Application 3/2023/0610 13 Clitheroe Road

**From:** [REDACTED]  
**Sent:** 21 August 2023 20:38  
**To:** Planning  
**Subject:** Nature of the plans presented for Application 3/2023/0610

EXISTING GROUND FLOOR &
ELEVATIONS

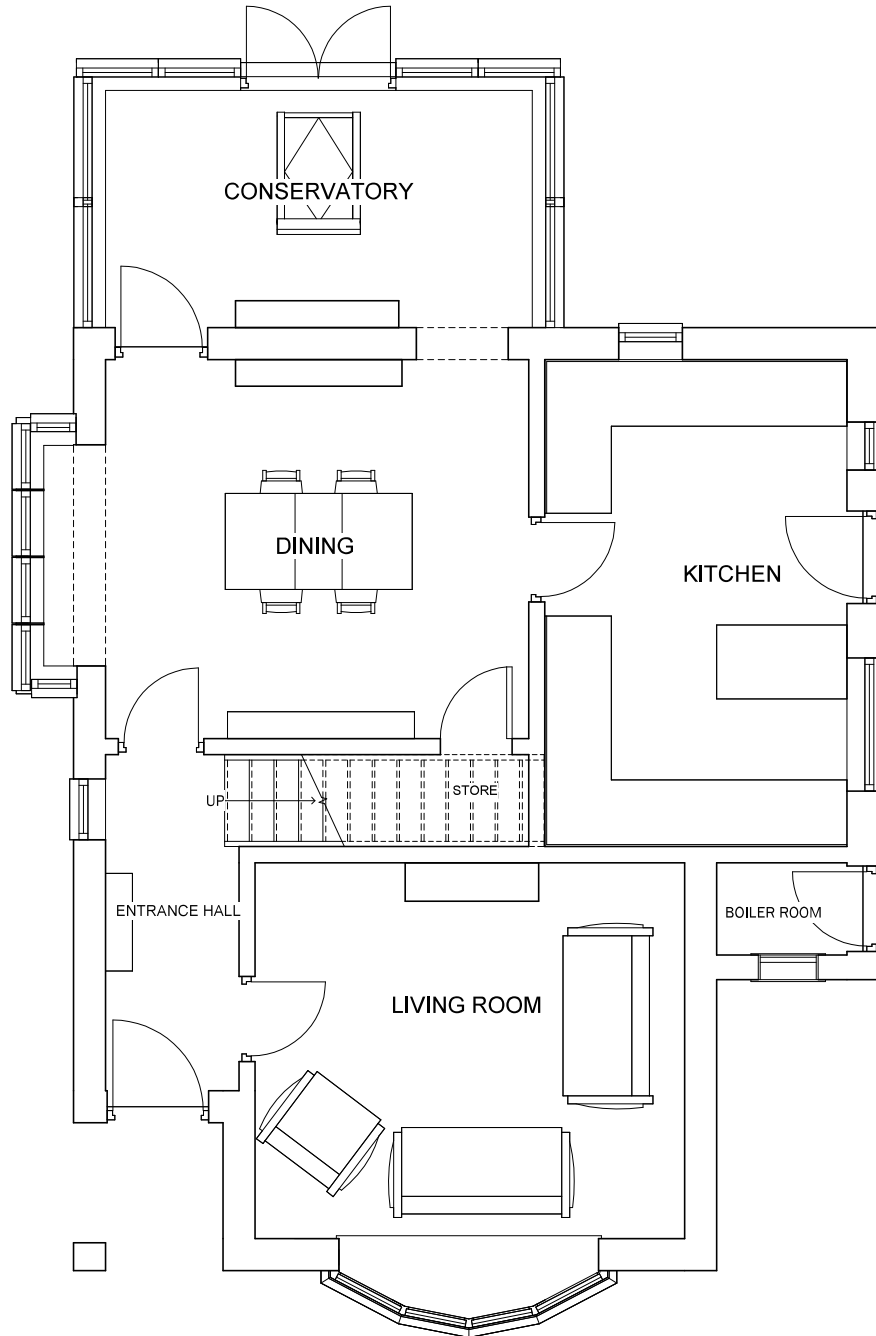
the Existing Floor plan file is presented at a scale of 1:25, the proposed ground floor plan at a scale of 1:50 the site plans at a scale of 1:100?

**PROPOSED FLOOR PLAN &  
ELEVATIONS**

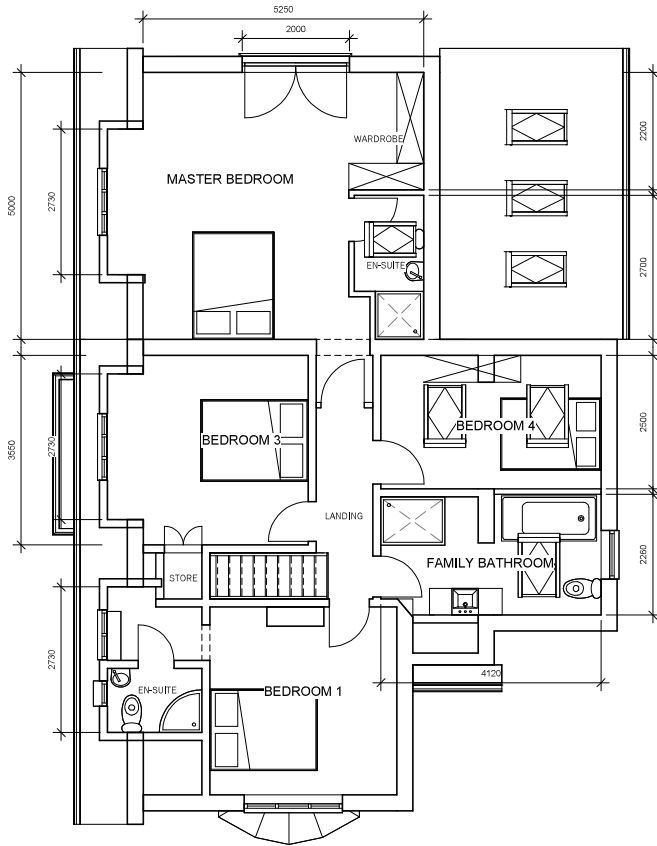
I have found it difficult to judge the impact of the side extension on the front view of the house as there is no proposed East elevation provided. I have written to the Director of Economic Development concerning this in a separate email. I can only calculate the width of the proposed property from the last file presented; the Site Plans in which the scale is deceptively small. This shows a path down the North side of one metre. This is a mere chink of light between No 13 (as proposed) and the neighbouring property.

2 I have noted that no elevation view of the proposed development from the East is shown. In my opinion, the increasingly small scale on the documents as presented gives a misleading view to the lay observer. The lack of a proposed front elevation means that the plans do not do justice to the impact of the development on the view from the East. If I was of a suspicious mind, I might suspect that the person submitting the documents was trying to ensure that the unpractised eye would not spot that the property was being widened considerably.
